RE: SUBMISSION TO SSD-78156462 FOR RESIDENTIAL FLAT BUILDING WITH INFILL AFFORDABLE HOUSING

Thank you for the opportunity to comment on State Significant Development (SSD) application (SSD-78156462) for demolition of existing structures and construction of a residential flat building including infill affordable housing at No. 12-16 Bent Street, Lindfield.

Ku-ring-gai Council's objection/submission to SSD- 78156462 for residential flat building with infill affordable housing at No. 12-16 Bent Street, Lindfield

Title	Drawing Number	Revision
B1-GENERAL ARRANGEMENT PLANS LEVEL 09 FLOOR PLAN	AR-DA-B10120	A01

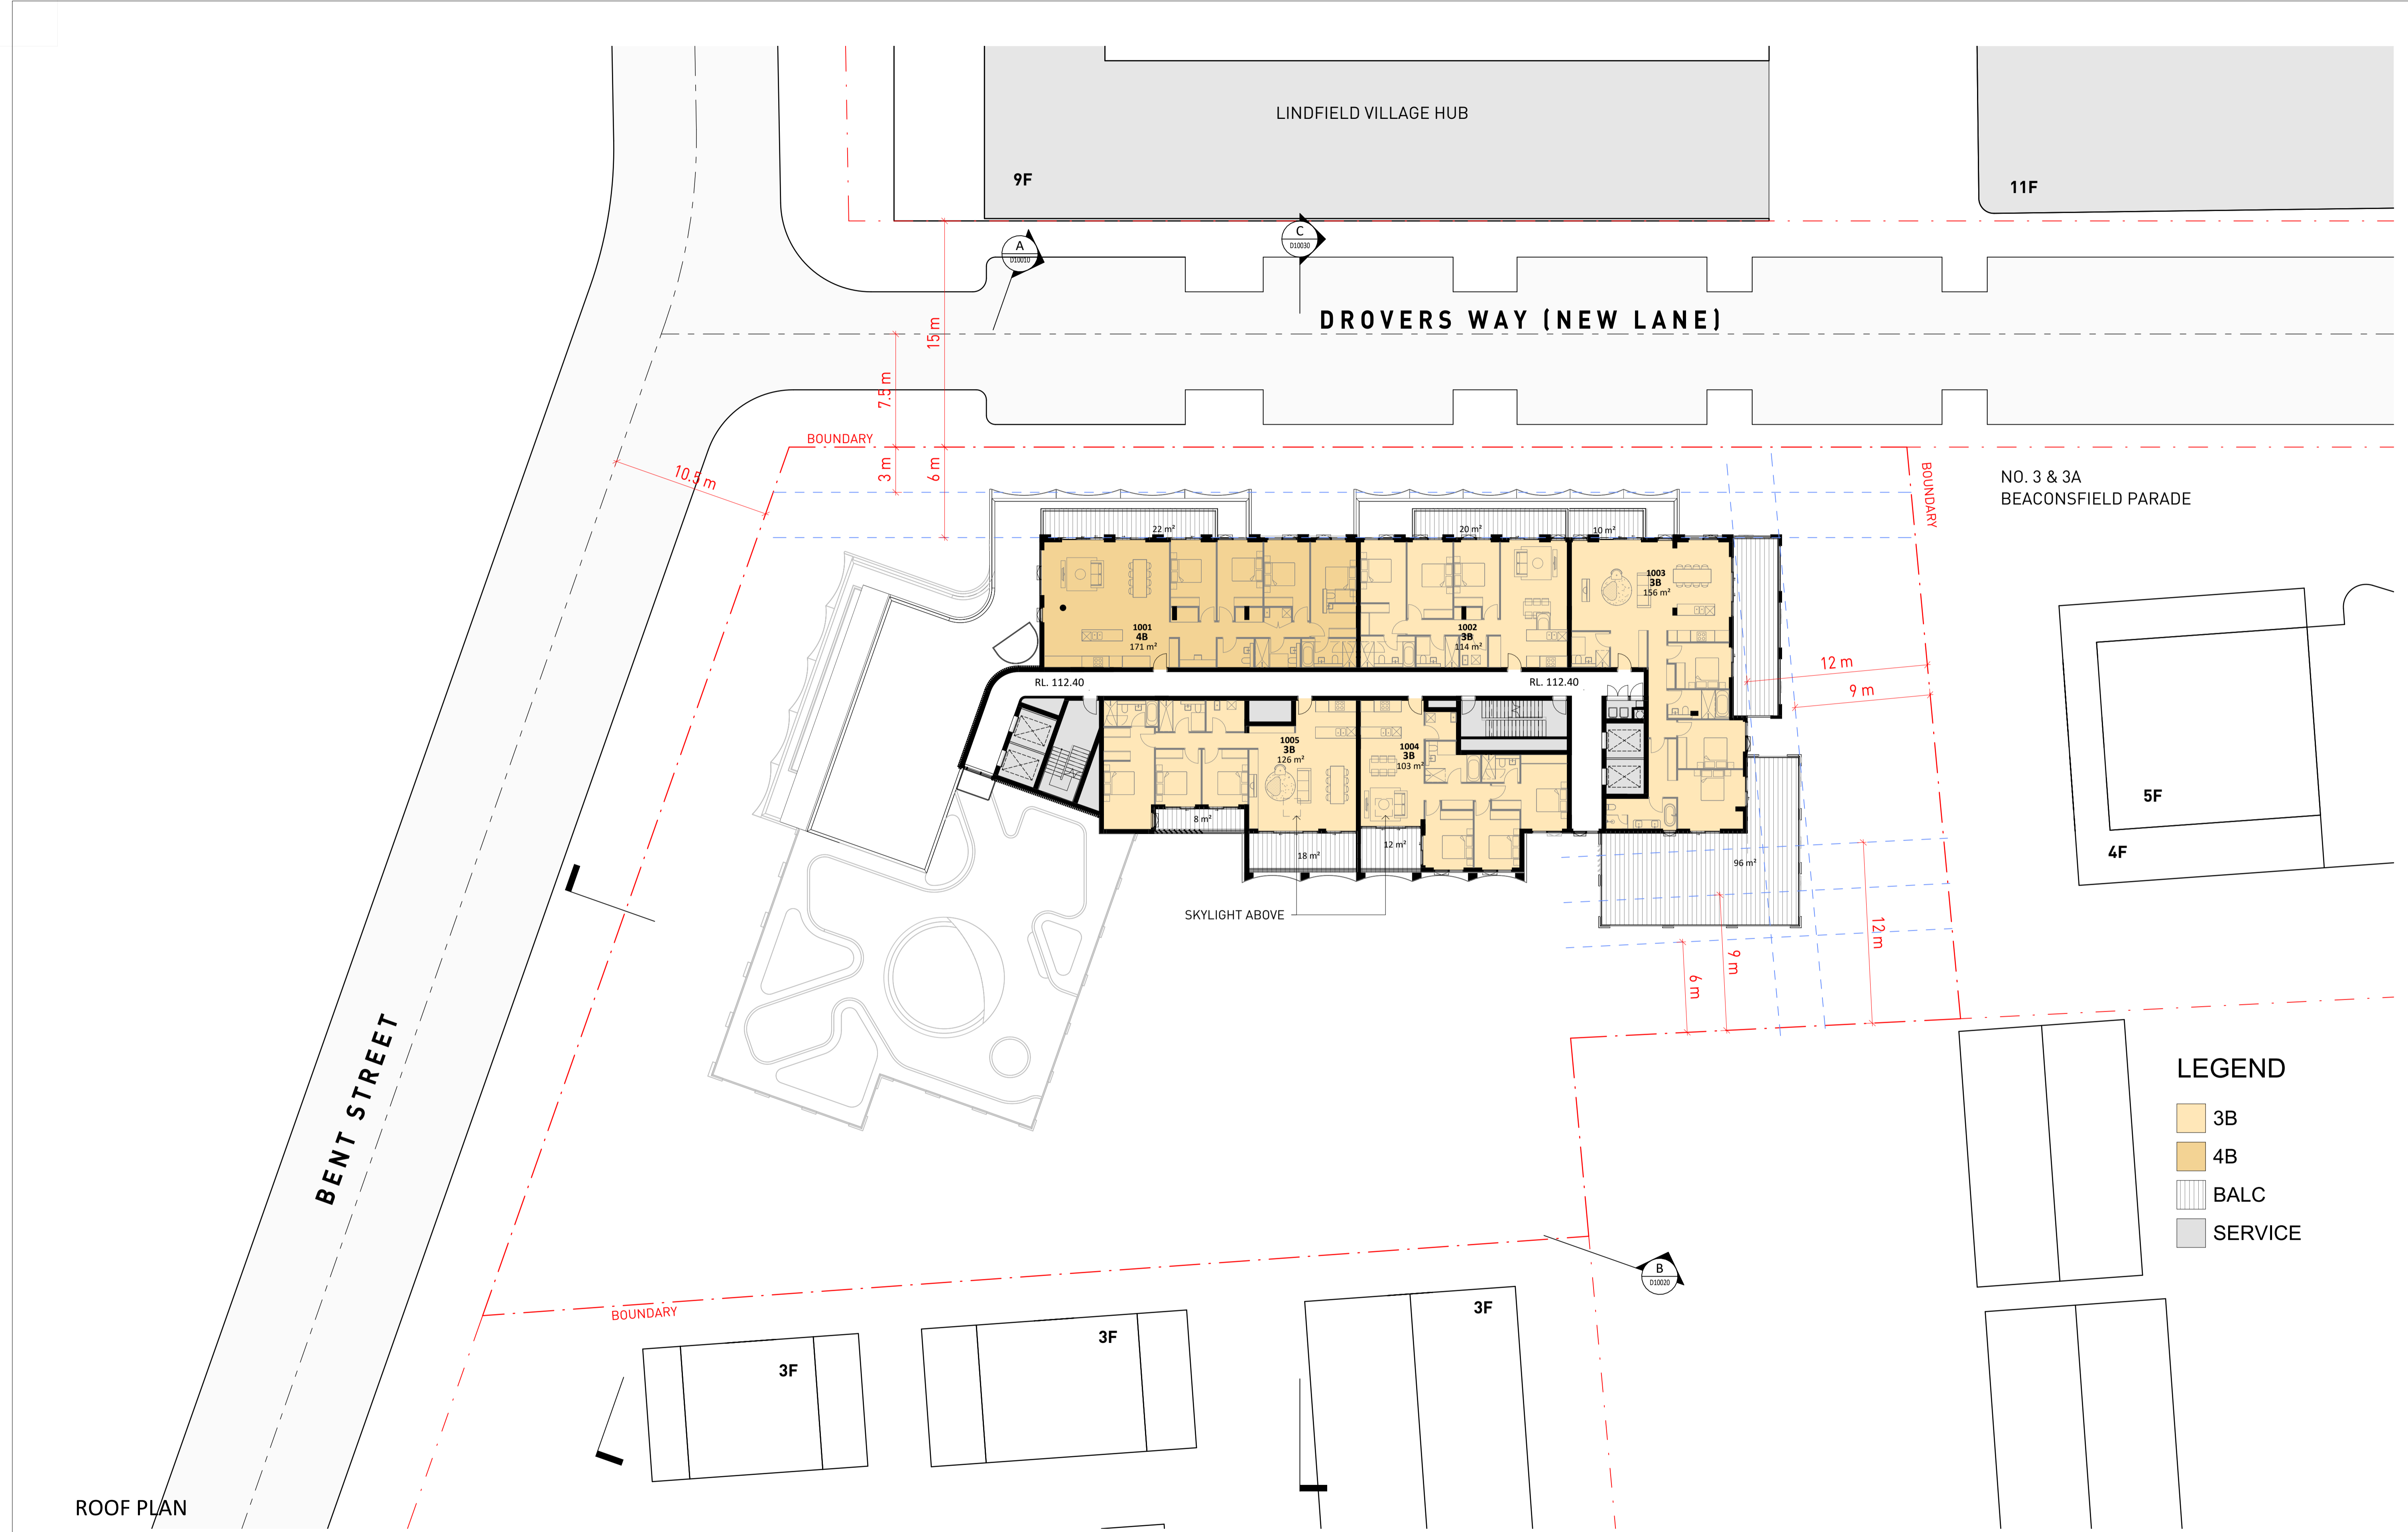
The proposal includes a tenth floor on the eastern side of the building. The majority of the top floor

breaches the building height standard and is not set back the required 2.4m from the outer face of the level below (level 9) as required by control 2 in Part 7C.8 in KDCP. Further, the GFA of the top floor comprises approximately 74% of the floor below and does not comply with control 1 in Part 7C.8 of KDCP which specifies a maximum area of 60% of the floor below.

The top floor should be reduced in GFA to reduce overshadowing and to achieve compliance with objectives 1 and 2 in Part 7C.8 in KDCP. As proposed, the balconies of level 10 extend over the roof of the floor below and the top storey is not sufficiently visually differentiated from the floor below (**Figures 7 and 8**). Concerns relating to overshadowing are also raised (refer Amenity comments below).

3 PLATINUM APARTMENT - 2B UNIT (UNIT 214)
1 : 100 UNIT 214, 315, 414, 514,

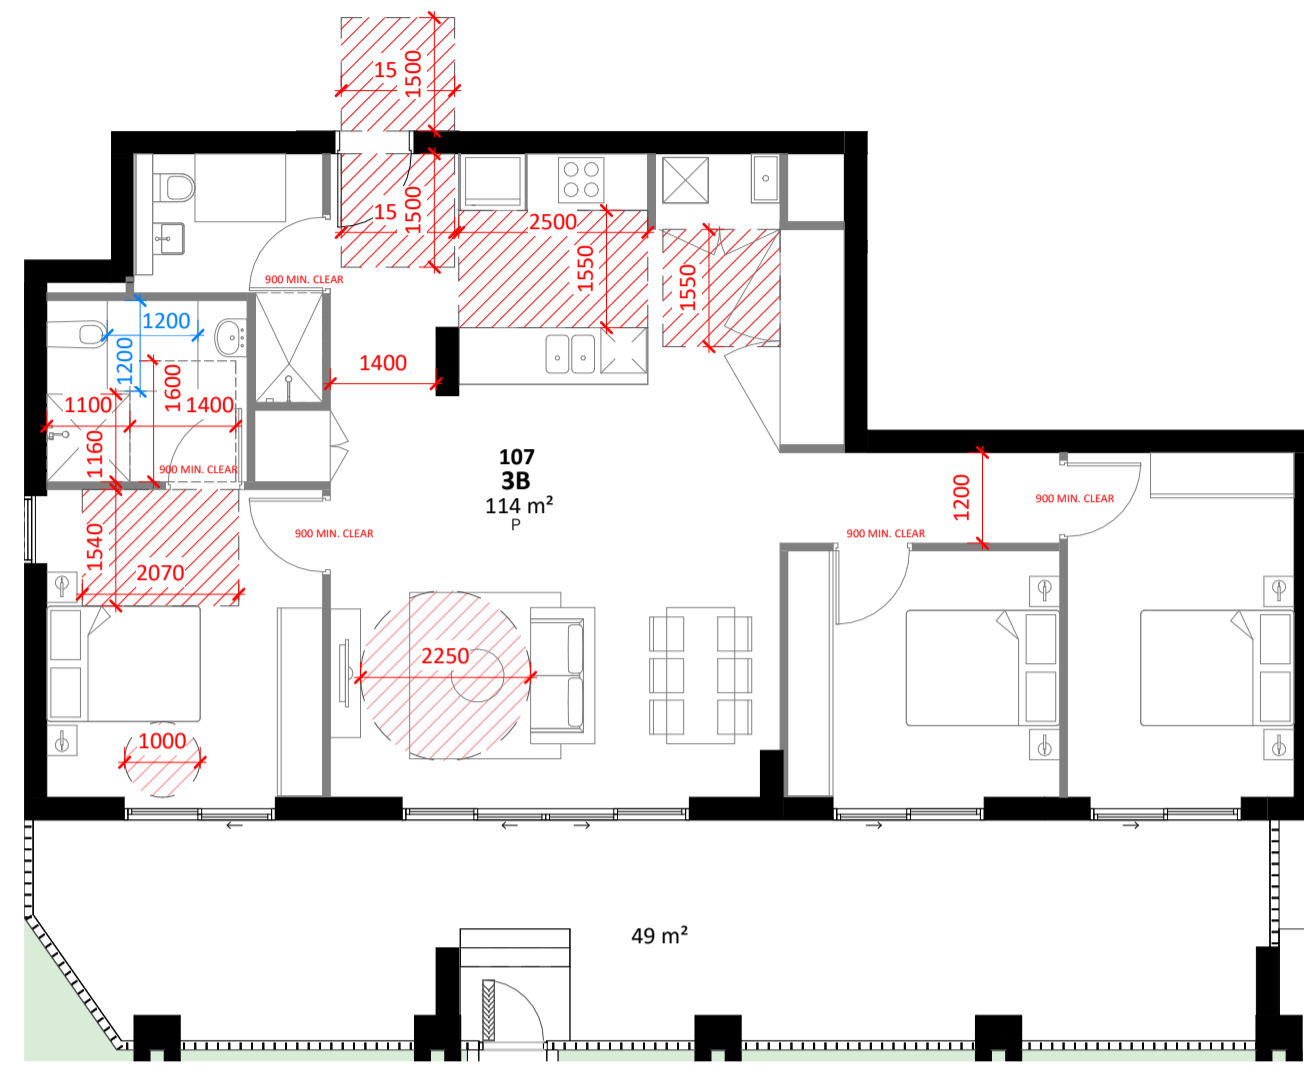
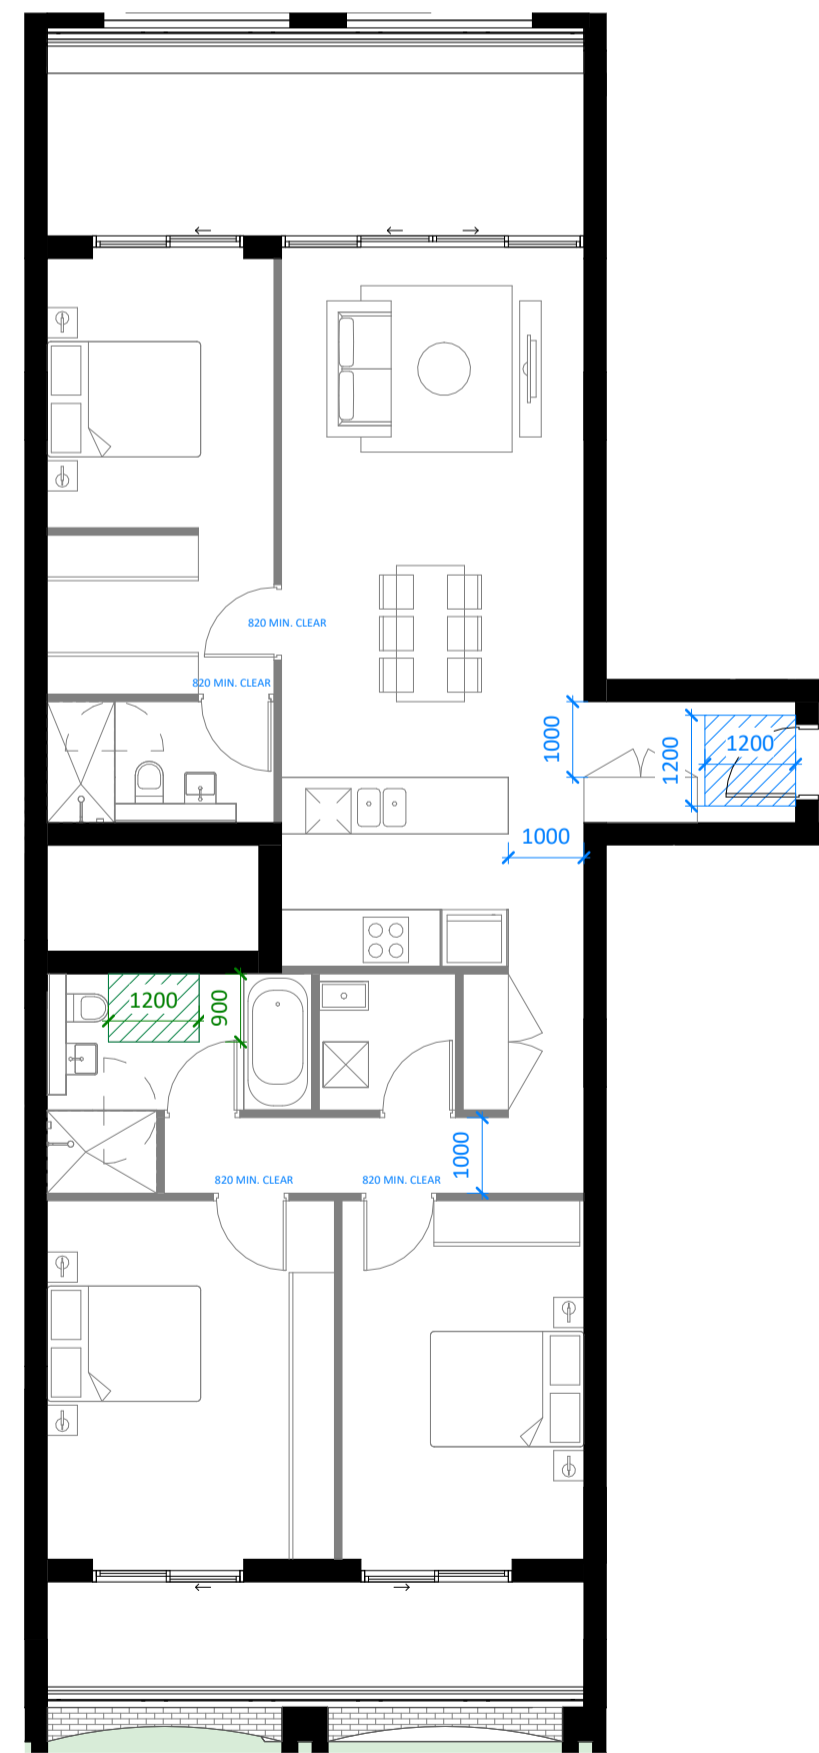
The amenity of some of the affordable housing units is compromised. A large number of affordable units receive neither cross-ventilation, nor solar access (including but not limited to Unit 101, 201, 301, 401, 501, 214, 315, 414 and 514). The applicant should ensure that the amenity of the affordable units is not unfairly compromised. This issue was raised at pre-DA stage and has not been addressed.
